CITY OF PORTLAND, MAINE

HISTORIC PRESERVATION BOARD

November 6, 2017

Re: Proposed Ground Floor Alterations and Masonry Repairs
Dear Mr. Hagge:

Storefront Dimensions and Configuration prepared by Lee Hulst at the 11/1/17 Meeting of the Portland Historic Preservation Board

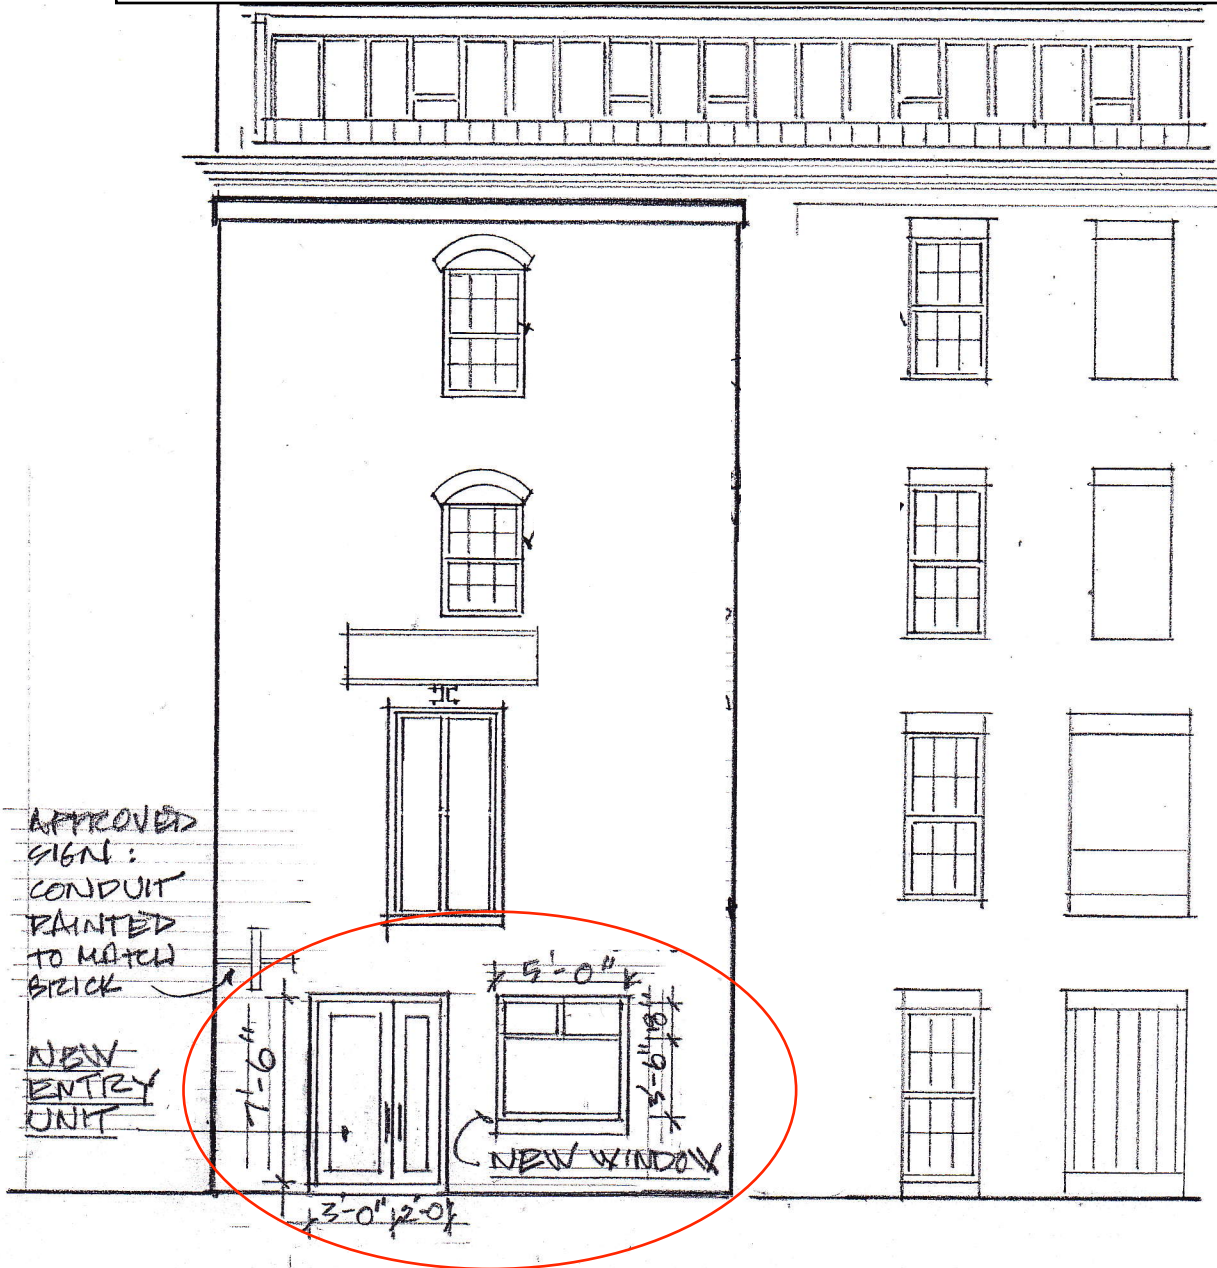
- Approval is based storefront dimensions and configuration as shown in drawing prepared by Lee Hulst and distributed at the 11/1/17 meeting.
- Door hardware to have dark, recessive finish.
- Staff to review and approve mortar test patch prior to proceeding with repointing/masonry reconstruction.
